Planning Application Ref: AW/316/21/T

Location: Stratton, 9 Kingsway, Aldwick, PO21 4DQ

Description of works: Fell and remove 2no. field maple trees and 1no. oak tree

9 KINGSWAY

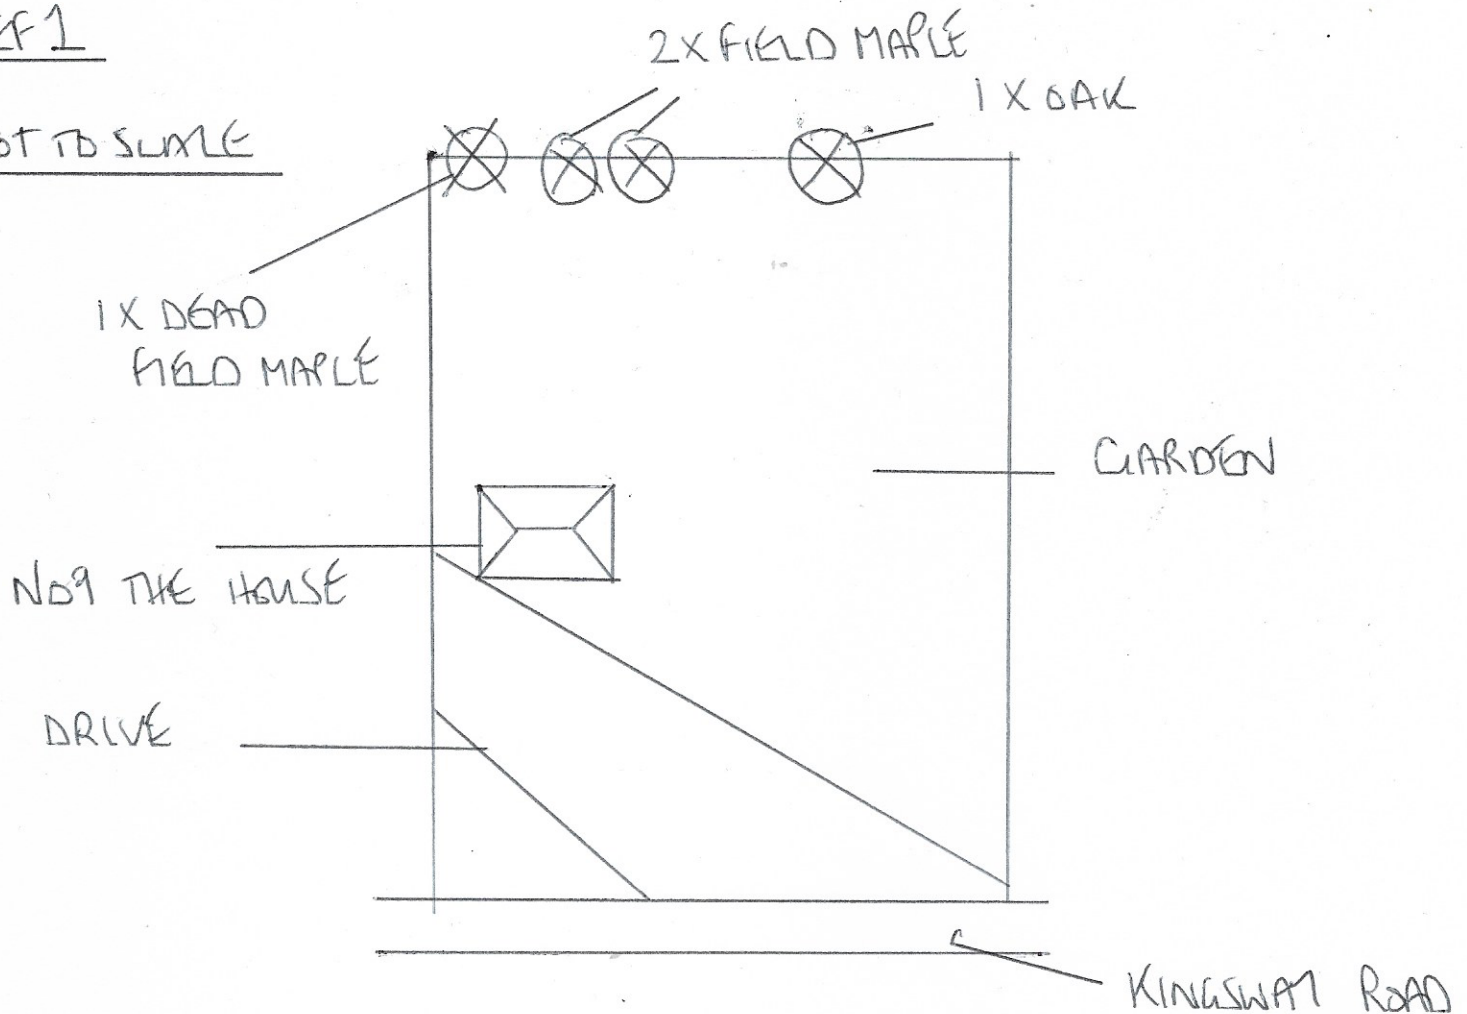
- T1 and T2 are both showing signs of physiological decline and becoming structurally unsound from stem decay. They are fast becoming unviable for safe retention.

- T3 is a much larger tree than the maples and occupies an off-centre position along the rear boundary, also growing out of the S edge of the ditch. It appears to be in a fine physiological state with a relatively unmodified limb framework. I saw no obvious evidence of significant disease or structural defect to justify its removal.

- The work proposed to T1 and T2 (maple) is justified on arboricultural grounds. There is limited scope for replacement planting as any tree of potential amenity value would struggle to establish beneath canopy of remaining trees. As such, we need not pursue replacement trees at this location but can take this opportunity to remind the applicant of the ecological value in standing deadwood and stump retention, wherever safe and practical to do so.

- T3 (oak) - The applicant has indicated concern about the stability of this tree but has not provided any physical evidence in support. My own ground-level visual assessment of the tree did not reveal any obvious signs of pathogen activity, structural defect or root-plate displacement; to suggest the tree could be structurally unsound and/or present an unacceptable level of risk for its location.

- For a tree of this age, stature, and apparent good health; a proposal to fell for the reason stated must be supported with evidence (e.g., ground disturbance, pronounced lean through to upper crown, video footage clearly showing atypical movement) to demonstrate the tree is most probably hazardous. If that evidence can be provided in support of a new application, it may be appropriate to propose crown reduction pruning instead of wholesale removal.

- As it stands, I recommend **REFUSAL** for this application.

- **I would like the applicant to be invited to agree to revise their work proposal** (by removing T3 oak) as part of the current application so as not to incur further delay. Such work would go some way to addressing their concerns whilst preventing undue loss to the landscape.
-

- If the applicant is prepared to re-submit in line with this advice, then I would be able to recommend **APPROVAL**.
